REPORT UPDATE

Application No: AW/25/15/A

Recommendation Report for Consent to Display an Advertisement(s)

PROPOSAL: 3 No. externally illuminated fascia signs, 2 No. non illuminated fascia signs & 2 No. non illuminated panel signs to various elevations (resubmission following AW/215/14/A).

FRONT ELEVATION

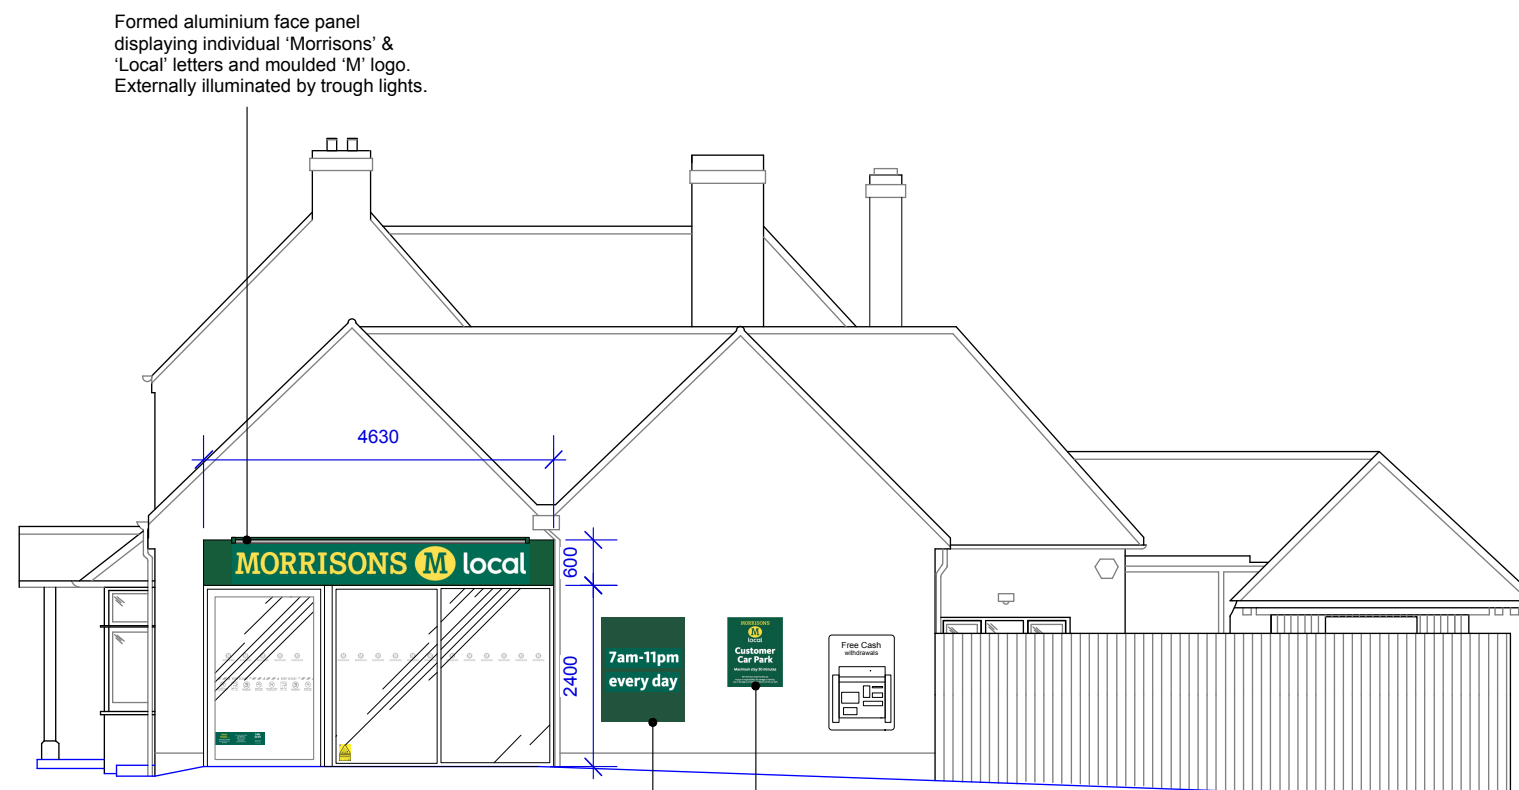
- * Request a 50% reduction in the size of the sign above the entrance on the eastern elevation;
- * Consider that the other car park and opening hours signs on the building do not add to the advertising of the store and look cluttered and out of place in the village environment;

It should be noted that the two small signs on the eastern elevation do not actually require advertisement consent and have only been included within the application for completeness.

Front elevation: the sign seems located so that it accommodates the space between the two openings. It is suggested that the sign is redesigned to include only the 'M local' element. This revised text could be slightly larger, but not such that it accommodates the entire section between the two windows. An alternative could be to retain reference to the old ship, and have a hand painted sign stating something like "M Local at the Old Ship".

Side elevation (main entrance): is there a need for so many signs on this elevation? The number, size and location are visually cluttering. Could the hours of opening be placed on the third glazing panel of the opening, and the car park sign located closer to the cash point?

The applicants did also agree to make a change to the two non-illuminated fascia panels (signs 4 & 6) on the eastern elevation. They have reduced the size of these two signs and repositioned them so as to align with the top of the approved ATM. This tidies up their appearance on this elevation. It should be noted that these two signs are now 0.3sqm in area and as such benefit from Deemed Consent under Schedule 3, Part 1, Class 2 of the Control of Advertisement Regulations (2007).

Project No.
R14/15
DRAWING No.
D/24
REVISION
F
SCALE
**1:200 @ A3
1:100 @ A1**
DATE
JUL 2014

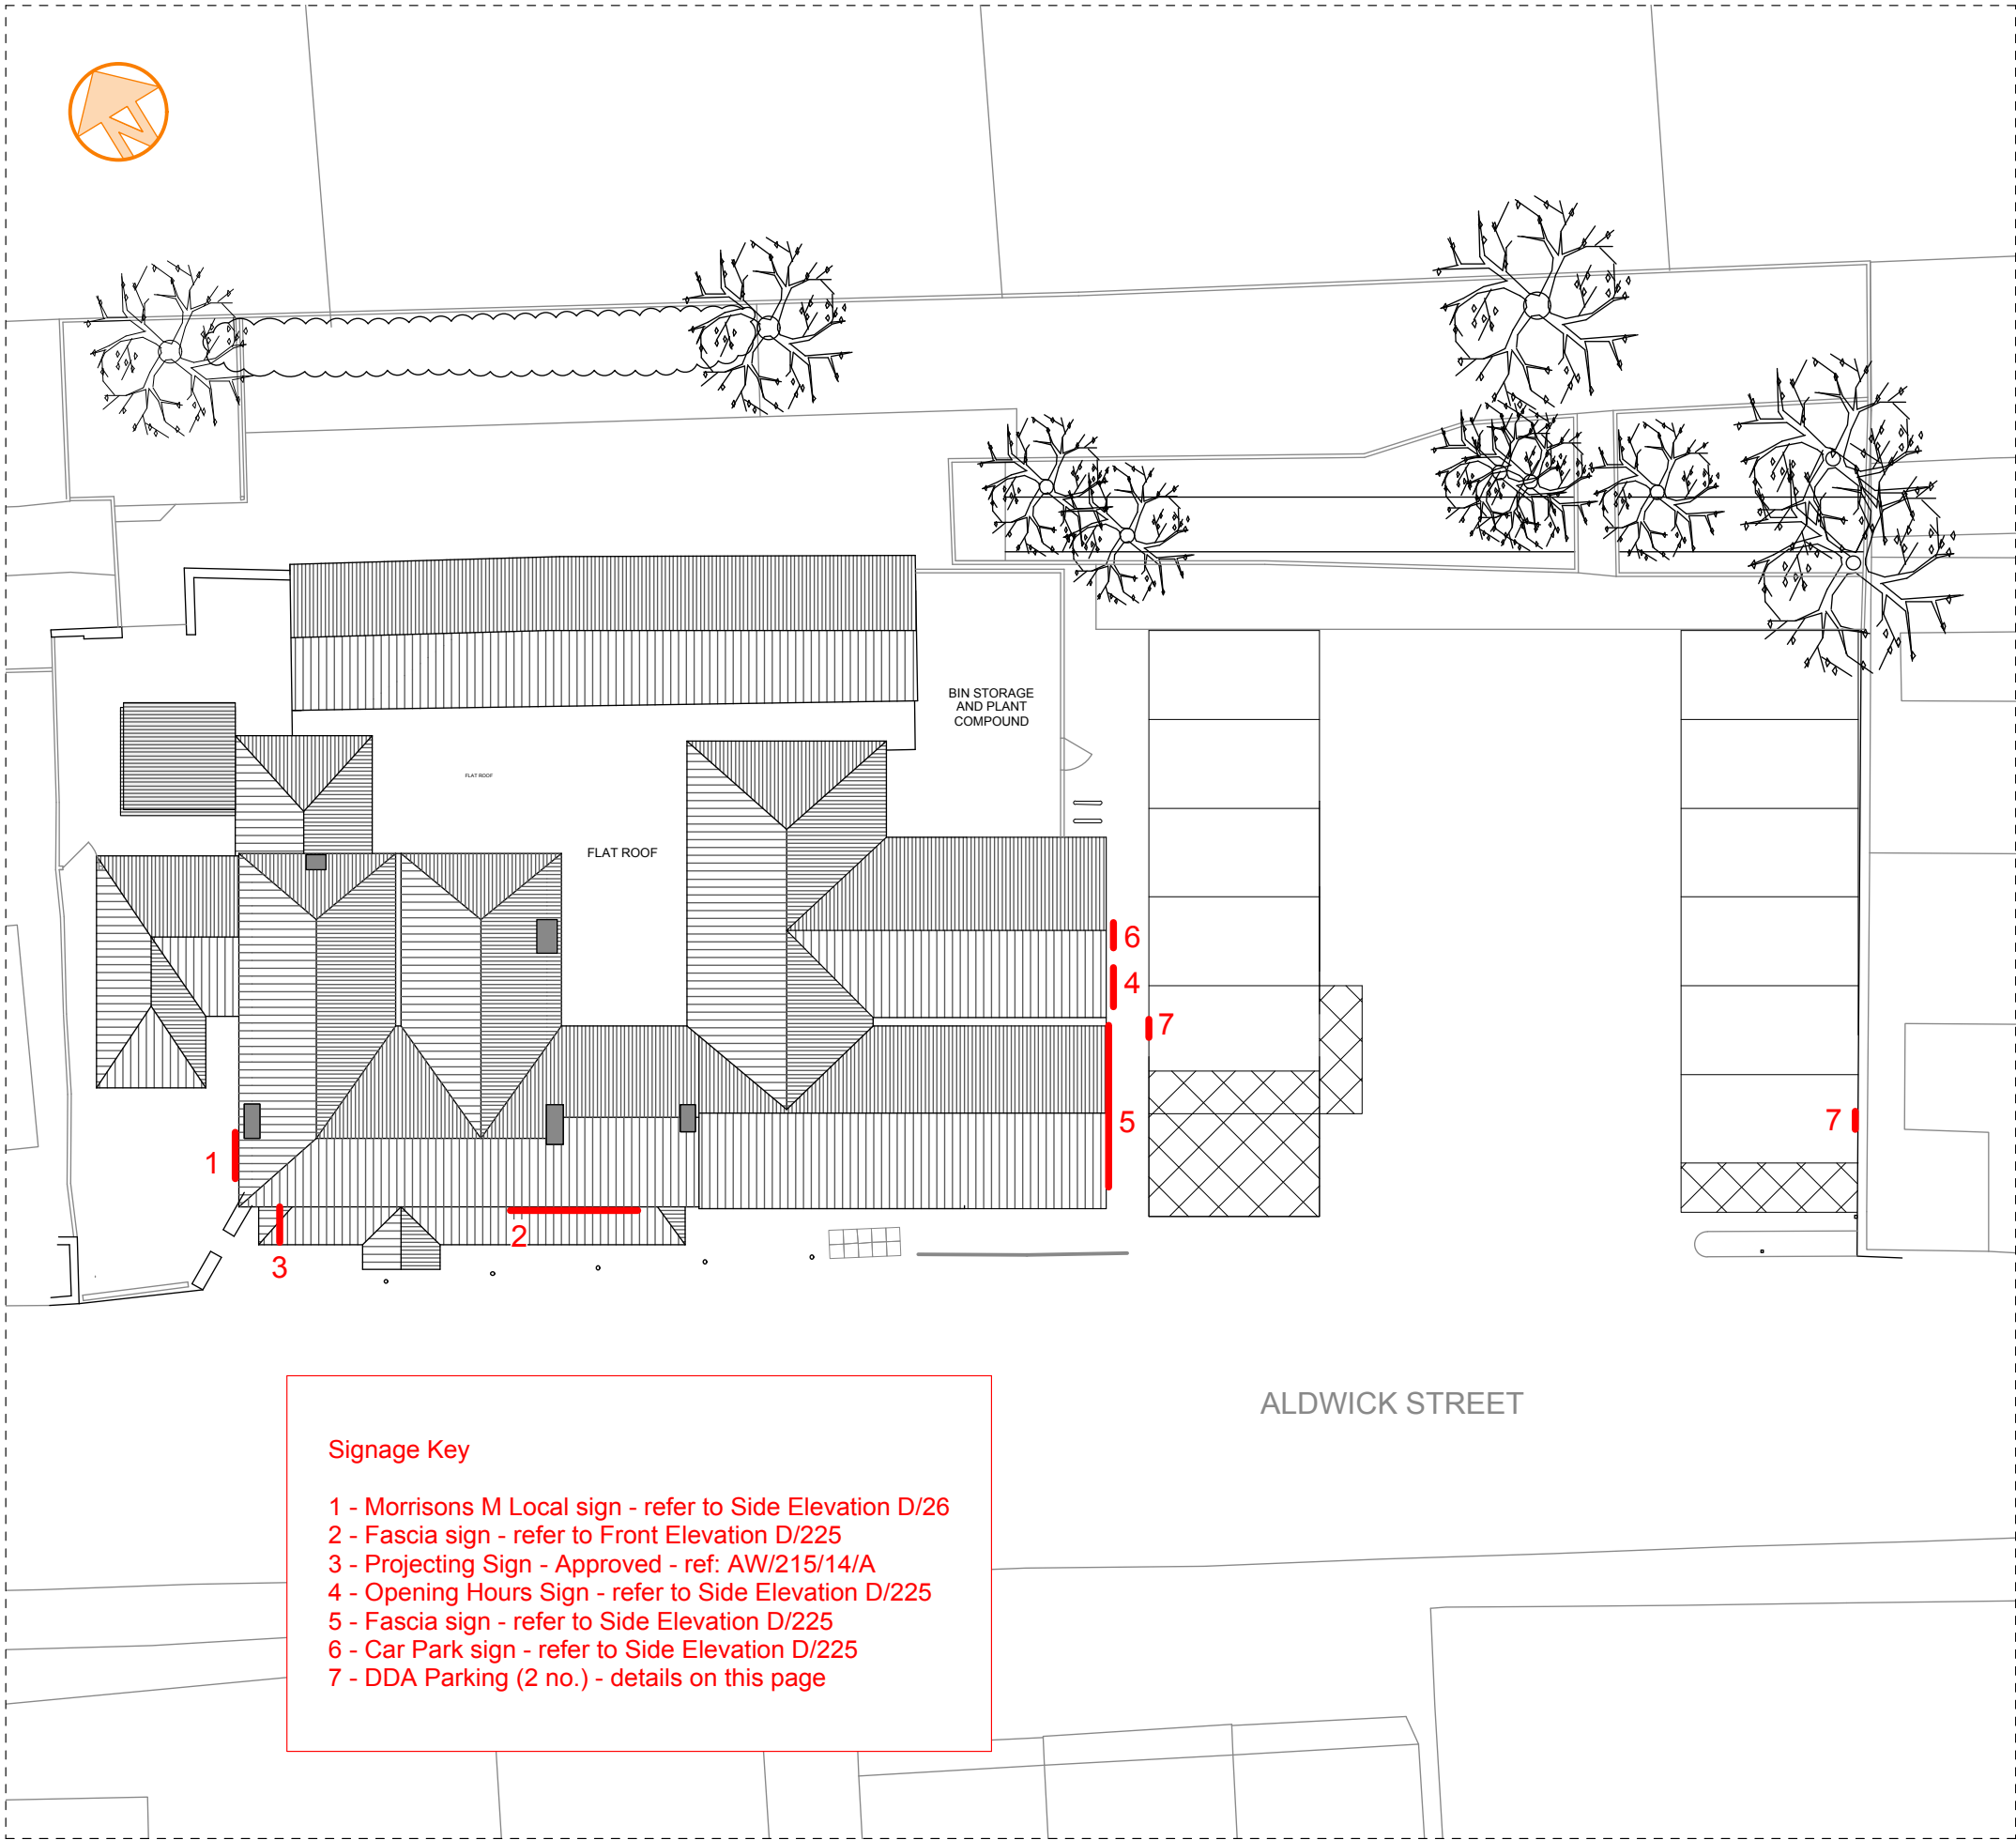
- * Sign 6 is not necessary as it is obvious that there is a car park;
- * Use of steel posts for the two sign 7's - these add clutter to the site;
- * Permitting these signs will set a precedent for other retailers;
